Project **The Linnets, Clacton Road, Thorrington, Colchester CO7 8JW**

Title **Design Development from Pre-Application Advice Ref. 23/30154/PREAPP**

Date **12 February 2024**

4 EAST - GARAGE REMOVED FOR CLARITY

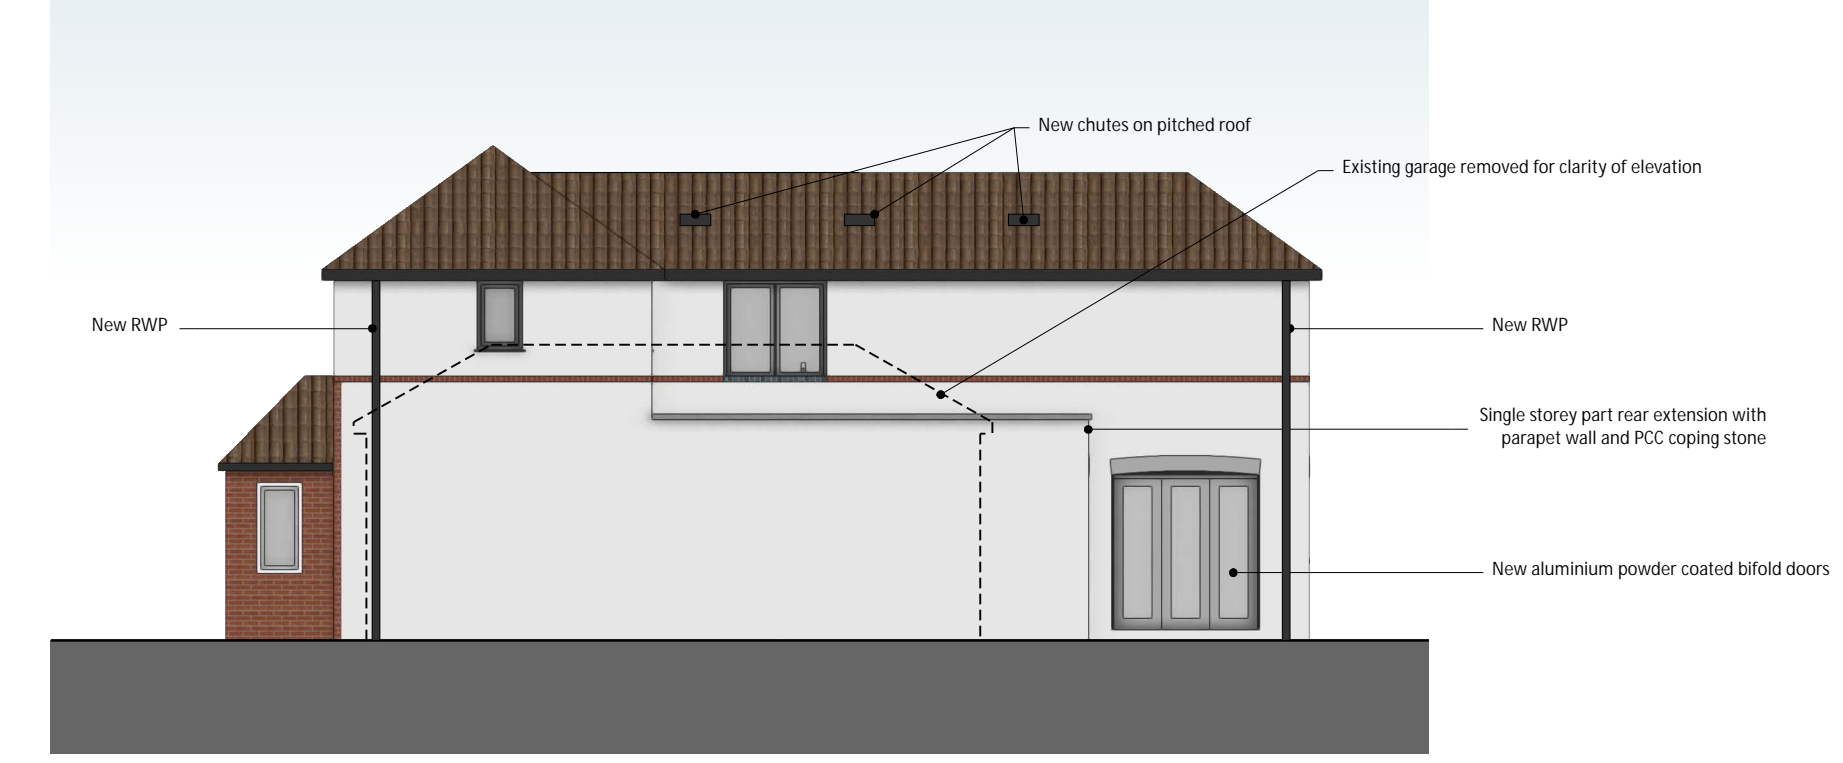
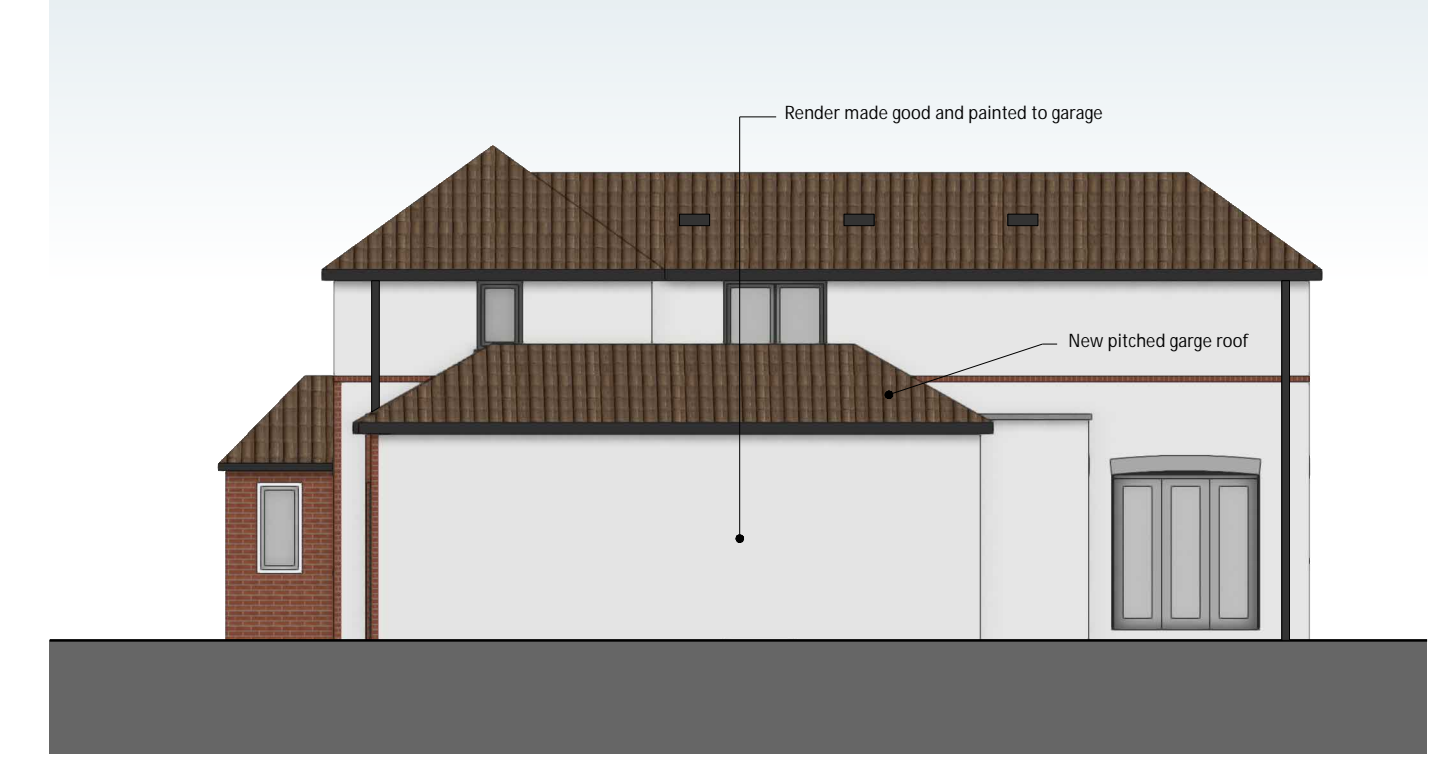
4	<p>The extension also will need to be moved back away from the front elevation of the house by approximately 1 metre so that the built form is subordinate to the main dwelling.</p>	<p>This has been incorporated into the application scheme,</p>

DRAWING  
**PROP: GROUND AND ELEVATIONS**

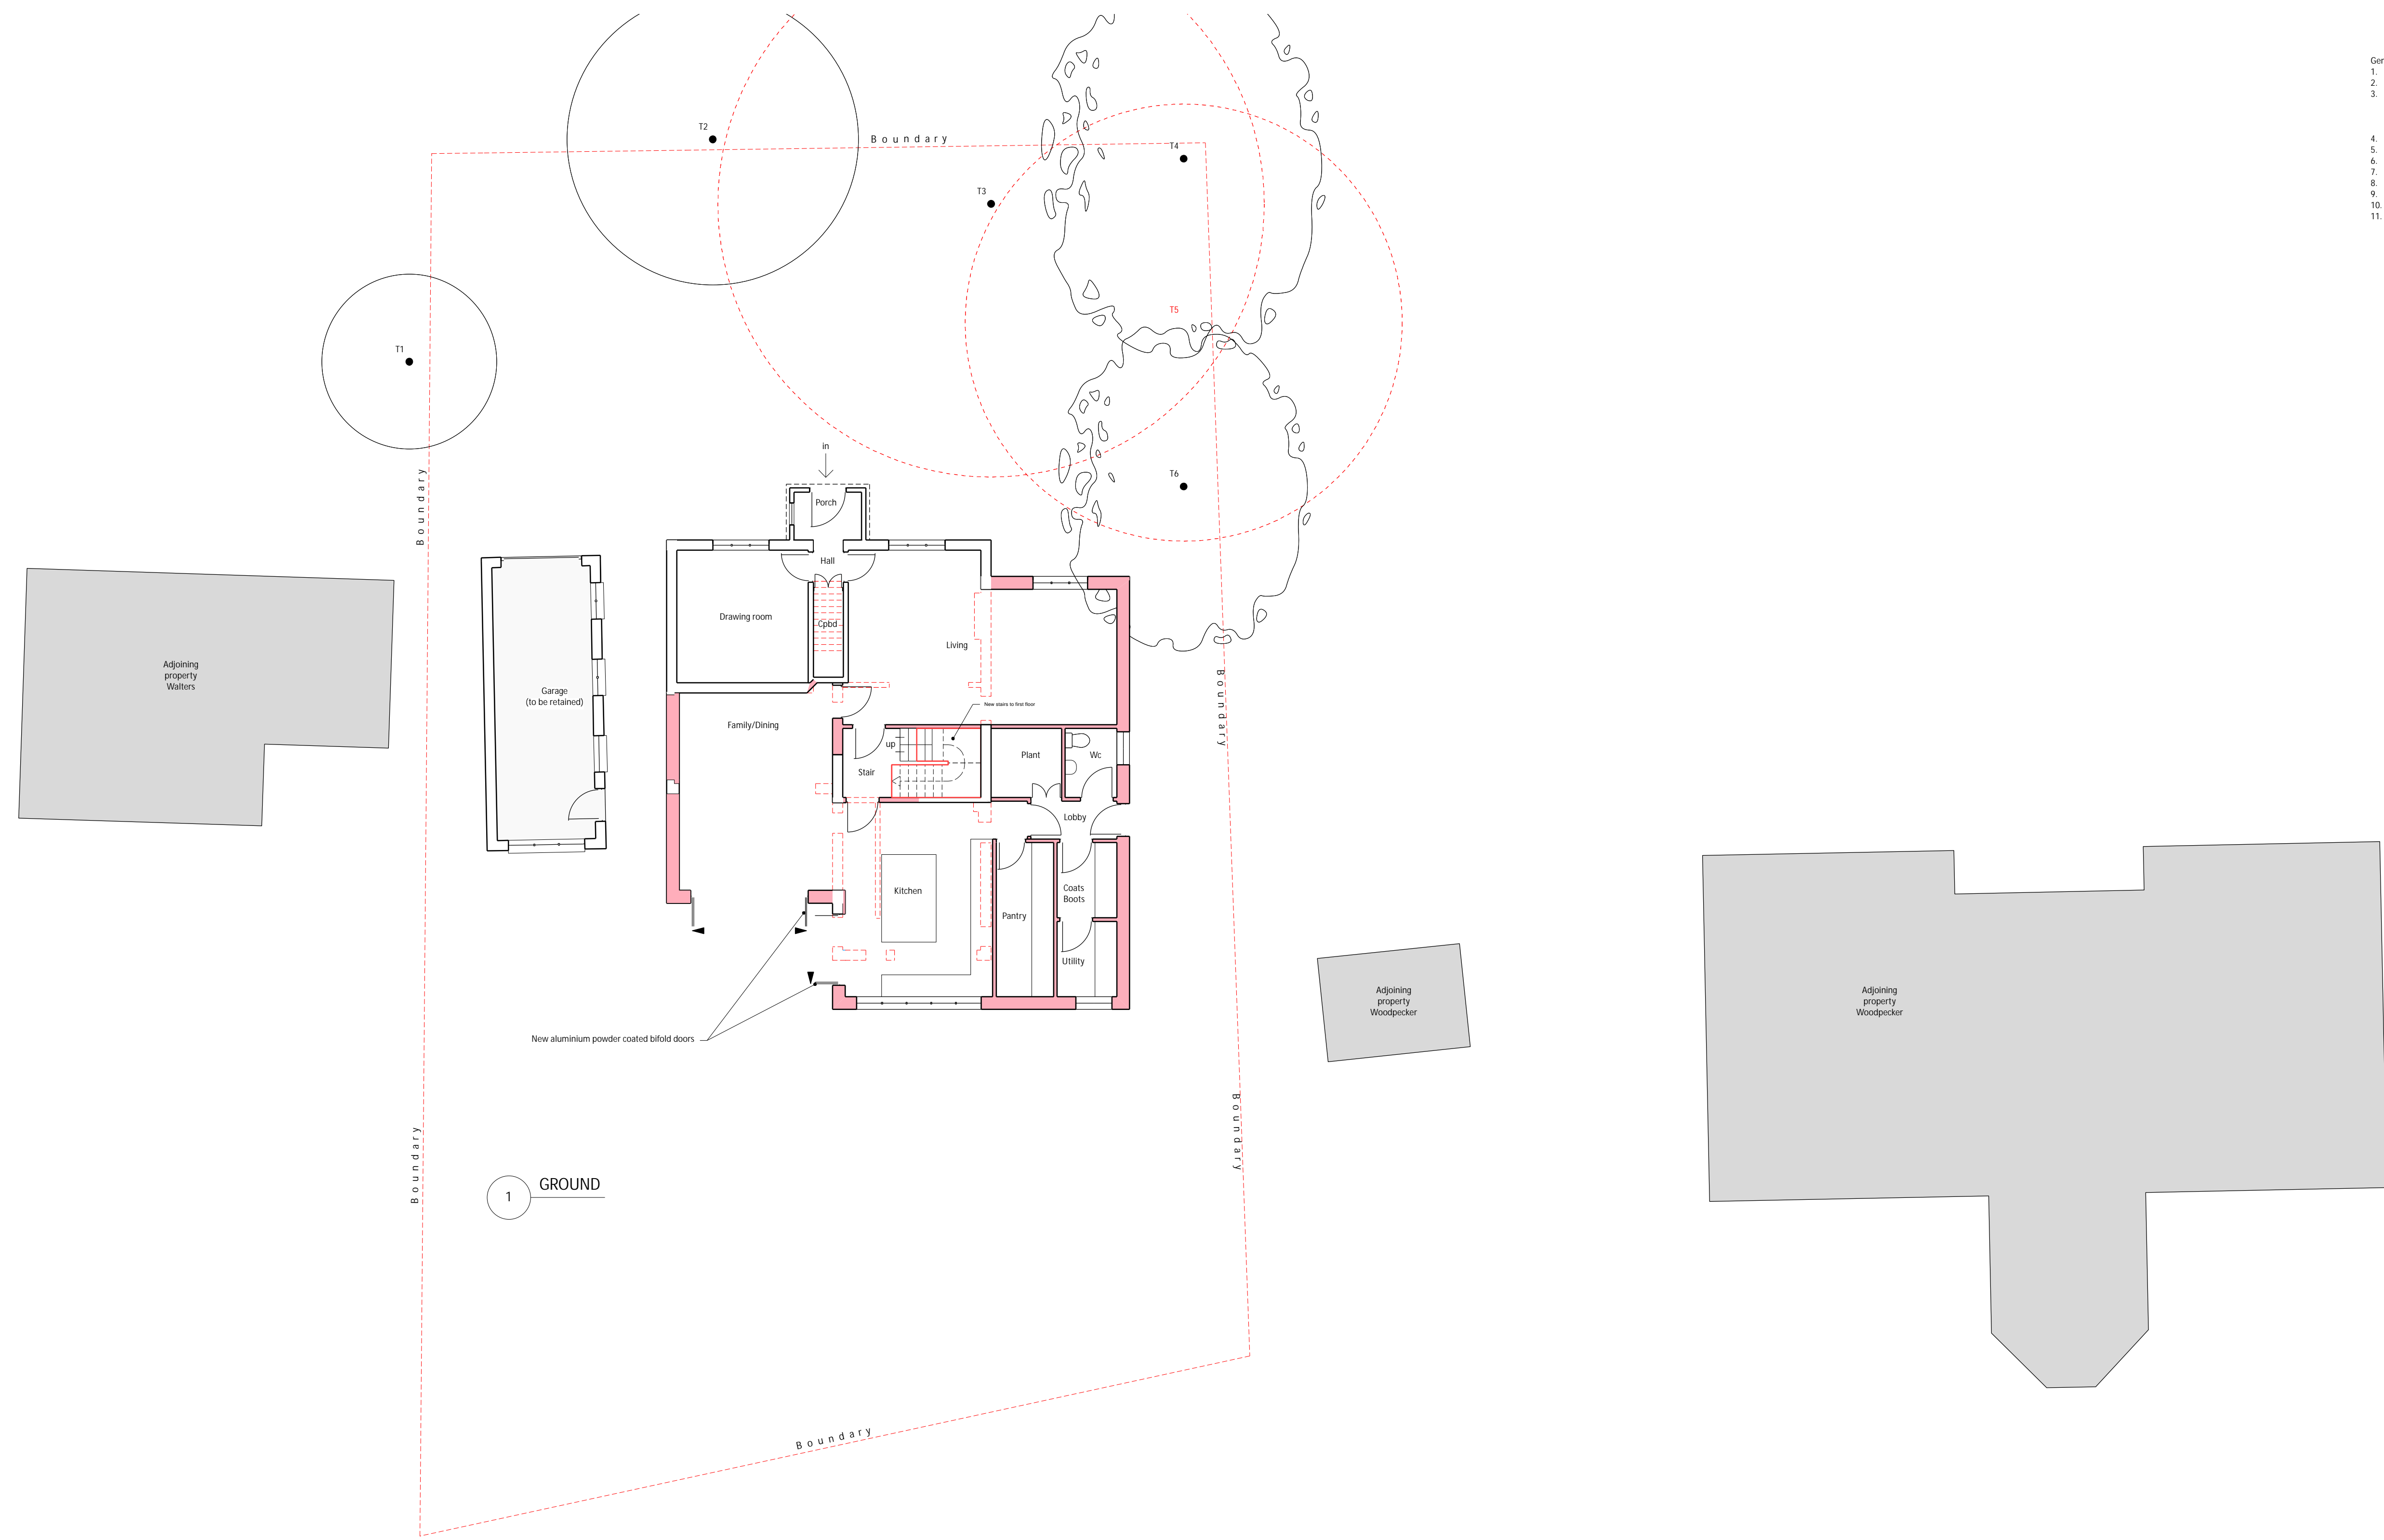
Ref	Tendering District Council (TDC) Pre-Application Advice Ref. 23/30154/PREAPP	Stones Architects (SA) New Application Scheme
1	<i>The proposed two storey side extension will be located to the south east of the existing dwelling and it will measure approximately 3.7 metres in width and retain just under a metre to the side boundary extending out to 1.4 metres towards the rear of the proposed extension.</i>	The width between the east boundary and the new extension has been checked on site. The plot is wider than the ordnance survey data, this has been accurately plotted onto the application drawings.
2	<i>The overall height of the proposed extension, including its roof profile, is in line with the existing dwelling and this design arrangement is identified as a key concern because the side extension will lack subordination relative to the main dwelling.</i>	The roof design and geometry of the proposed extension has been re-addressed to show a subservient solution, with the ridge line of the new extension lower than the existing ridge of the house.

DRAWING  
**EXISTING SITE PLAN**

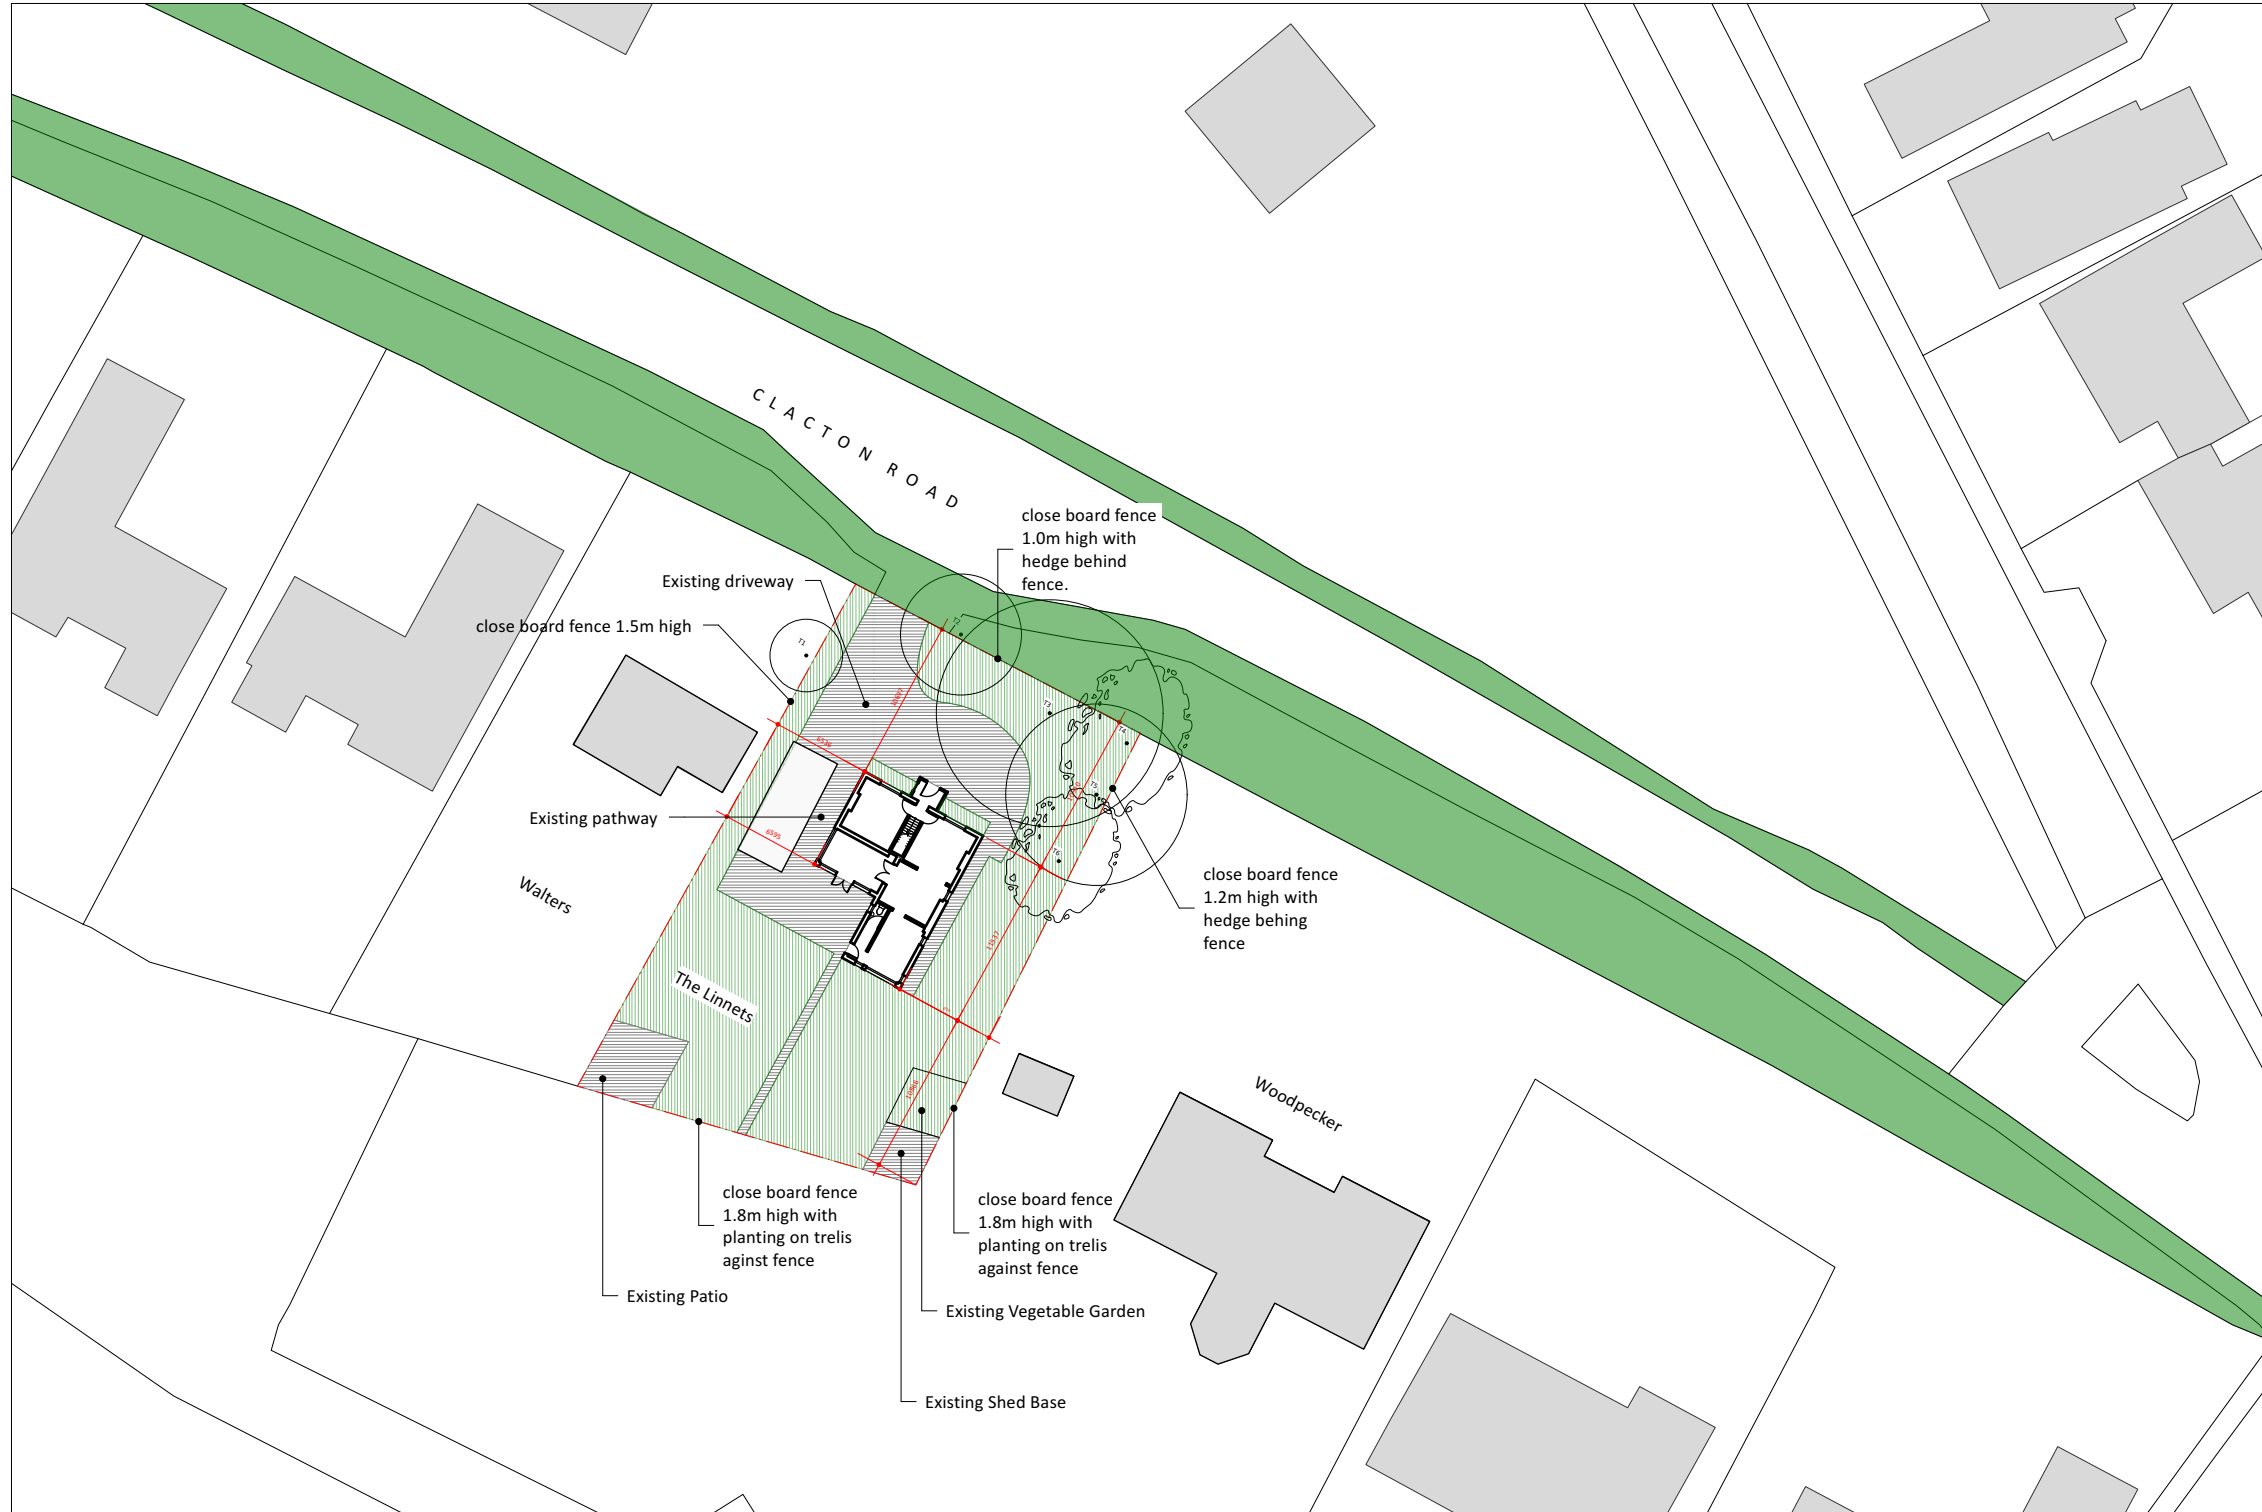
Ref	Tendering District Council (TDC) Pre-Application Advice Ref. 23/30154/PREAPP	Stones Architects (SA) New Application Scheme
3	<p>There are trees along the south eastern boundary, limited information is provided in respect of whether these will be retained/removed, regardless, these trees will come under pressure given the excessive width and footprint of the extension. The removal of trees will need to be confirmed when submitting a full planning application. Due to the close proximity to the neighbouring boundary and typically the character of the area retains a good distance to neighbouring boundaries, the excessive width of the extension will compromise these elements of spaciousness and you are advised to reduce the scale, bulk (see below) and width of the extension. This will also allow for landscaping to help soften the proposed extension and views from Clacton Road.</p>	<p>The existing trees have been shown on the application drawings. It is intended to remove 2no. trees as part of the proposal, these are as follows:</p> <p style="padding-left: 40px;">T3, Willow, this is interfering with the overhead incoming power, which effect the incoming service during or post a storm</p> <p style="padding-left: 40px;">T5, Fir to be removed due to the close proximity of the new extension</p> <p>It is intended increase the boundary planting, subject to consent to soften the views from Clacton Road, as suggested in the pre-application advice.</p>
